Our Case Number: ACP-323980-25

Ár dTag | Our Ref.
TII25-134619

RE: Proposed Water Supply Project for the Eastern and Midlands Region in the counties of Clare, Limerick, Tipperary, Offaly, Kildare, and Dublin by Uisce Éireann.

TII has reviewed *Statutory Consultation: Response to Submissions Report*, May 2026, and *Statutory Consultation: Supplementary Response to Submission Report*, June 2026. The submitted Response to Submissions Reports do not propose any alteration to aspects of proposed works that involve direct and indirect interactions with the national roads as identified in the original TII submission.

INDICATIVE CONSTRUCTION WORKING WIDTH - LAUNCH PIT AREA  
 SCALE 1:100

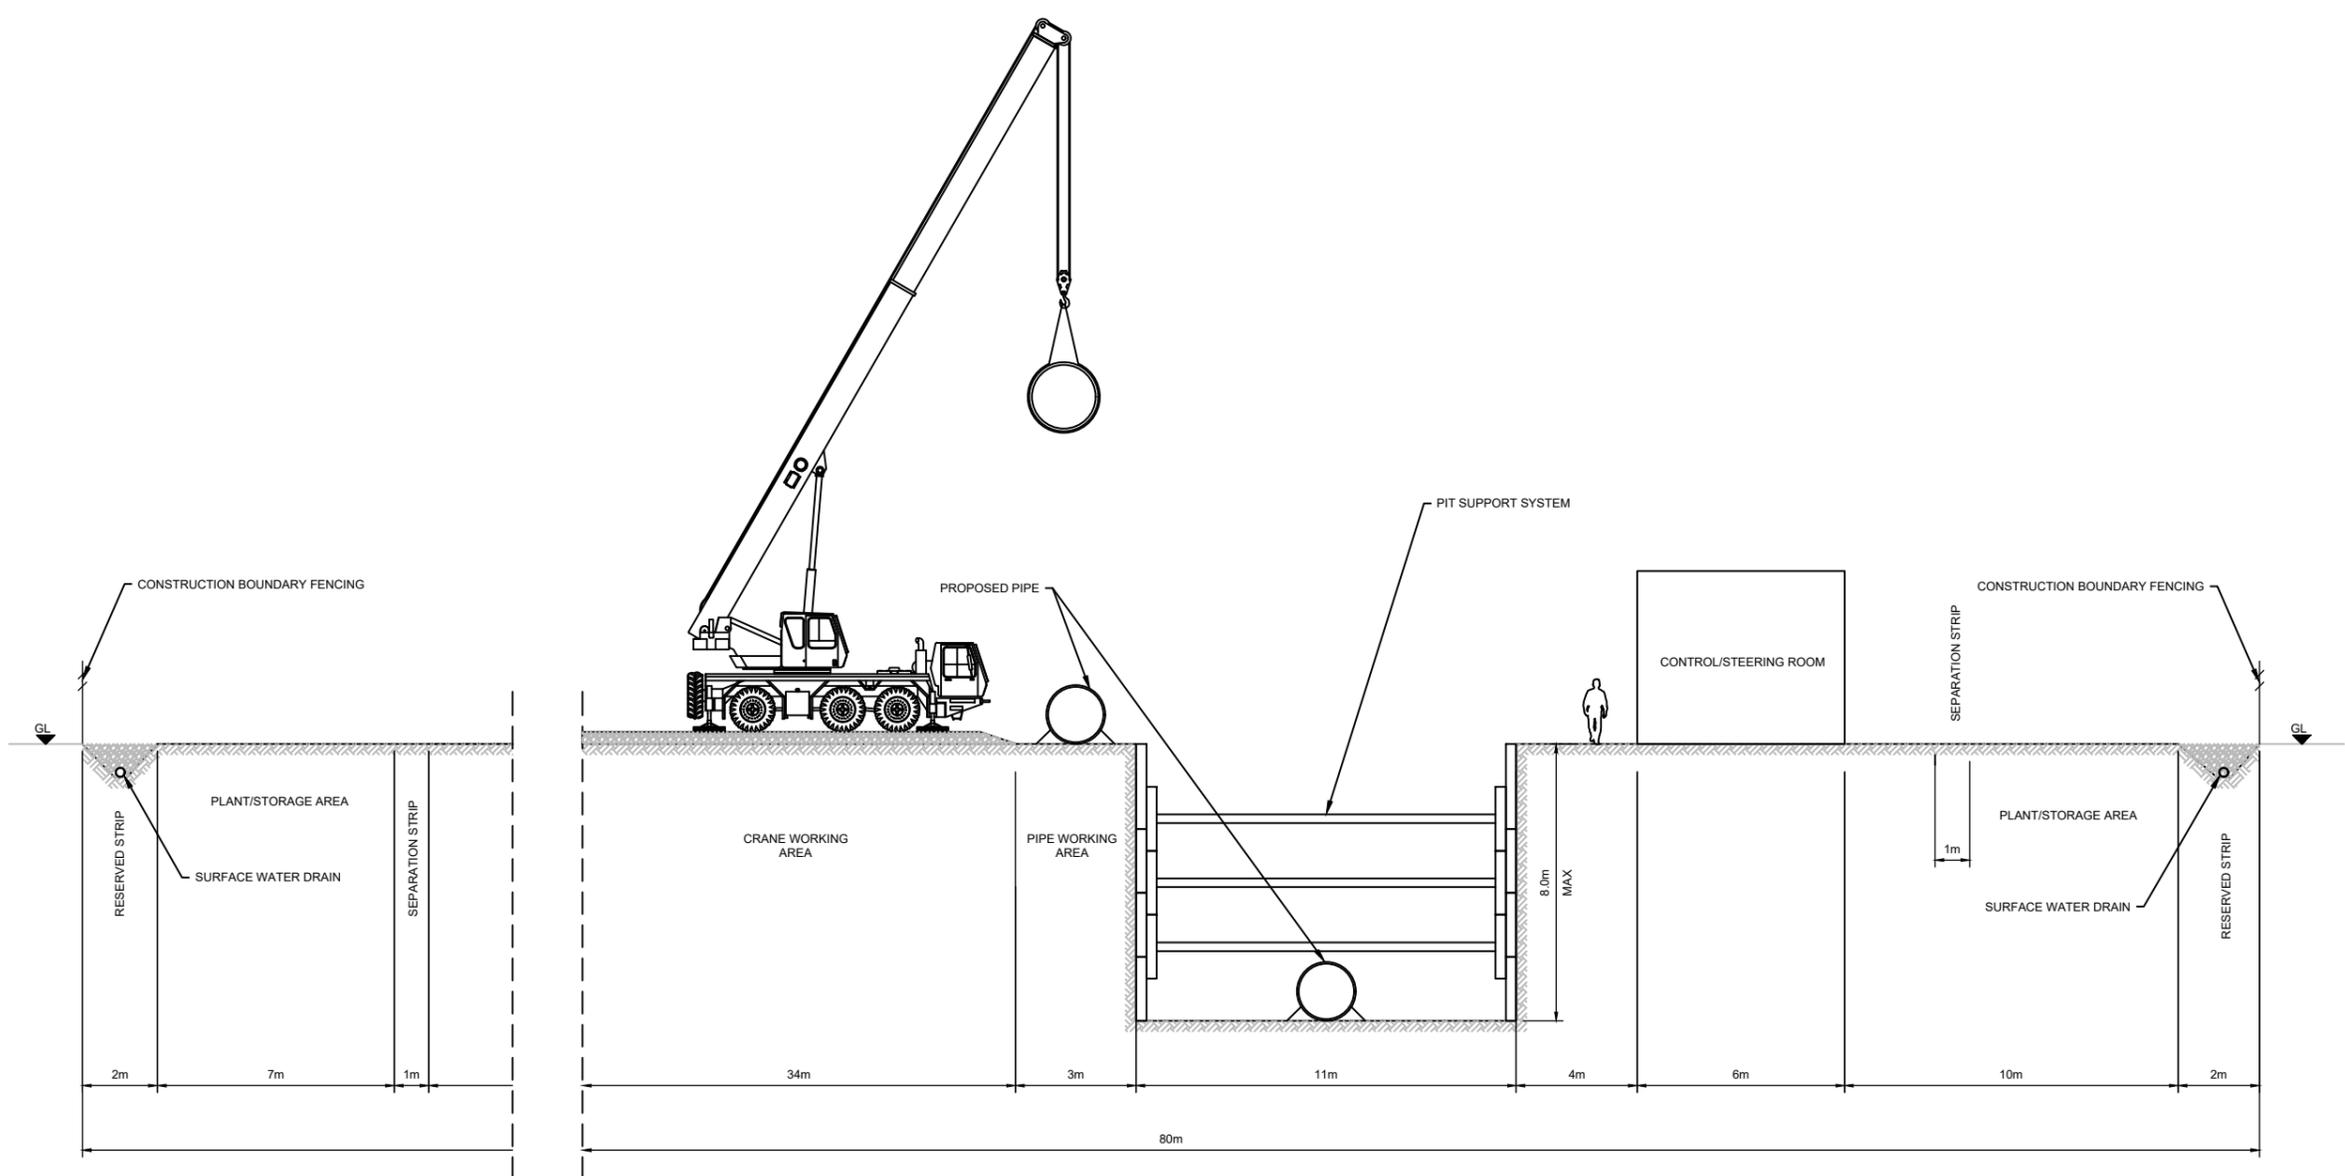
TII also reiterates that proposed horizontal directional drilling (HDD) crossings of the M7 Motorway require consent under Section 53 of the Roads Act 1993, as amended. General requirements for directional drilling under a motorway include;

- The launch and reception pits for the crossing are located outside the Motorway boundary,
- The crossings will be installed at such depth so as not to conflict with the drainage for the Motorway,
- Neither the Works nor the crossings will damage or interfere with the Motorway,
- Any maintenance and/or future planned upgrades of the crossings can be carried out without access to the motorway boundary,
- There are no bolted joints in that part of the crossing within the motorway fenceline, and
- A pre and post construction survey shall be required along the length of the crossing over the extents of the motorway boundary.

- **Recommended national roads network mitigation measures for proposed pipeline crossings of the national roads network**
 1. This permission does not approve nor imply consent for any works within the M7 Motorway reservation which shall be required to be achieved under Section 53 of the Roads Act 1993, as amended.

2. Prior to commencement of development, the Construction Environmental Management Plan (CEMP) shall be submitted for the written agreement of the planning authorities subject to the written agreement of TII. The Construction Environmental Management Plan (CEMP) shall include the following commitments in relation to trenchless underground crossings of the national roads network (M7, N52, N62 and N80) as appropriate:-

- a) a pre-construction survey along the length of the crossing over the extents of the motorway/dual carriageway boundary;
 - b) a commitment to and methodology for, the preparation and submission of, a post-construction survey along the length of the crossing over the extents of the motorway/dual carriageway boundary;
